From: Anita Gardner <Anita.Gardner@arun.gov.uk>
Sent: 17 August 2021 19:32
To: Planning.Responses <Planning.Responses@arun.gov.uk>
Subject: FW: PO/8/21/L Peckhams, Poling Street - Renovation of stable building

From: Anita Gardner
Sent: 17 August 2021 19:32
To: [REDACTED]
Subject: PO/8/21/L Peckhams, Poling Street - Renovation of stable building

The Conservation Officer has provided comments in respect of the above application. Can you please provide confirmation/ additional details in respect of the following:

Approximate total gross internal
floor space - 68.2 m²
734 ft²

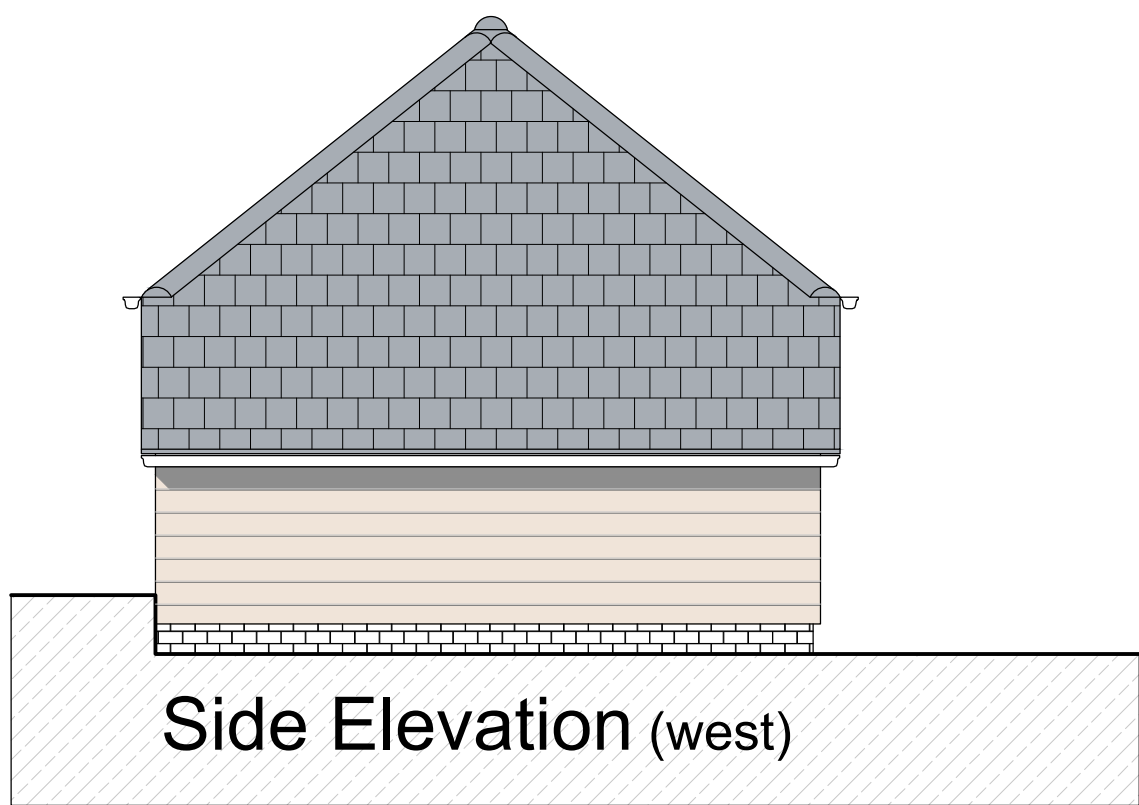
- The statements associated with the application identifies that the timber frame to the front elevation is to be retained on show by the installation of timber panels or glazing between the framework rather than being covered up as currently exists. However, this is not clear if the existing ones will be relocated in order to accommodate the large central glazed area, nor if the existing staddle stones will be re-used.

- It would help to understand if the rooms are to be left open to the roof void. Such an approach ensures that the character of the existing space can be understood as opposed to the installation of modern ceilings, which is a feature not associated with agricultural buildings such as this. This also needs to be confirmed.
- Careful consideration would also need to be given to any potential landscaping which could be necessary in order to facilitate such a use in respect of the need for any hard standings or pavements and planting. It would help to understand what this will look like.
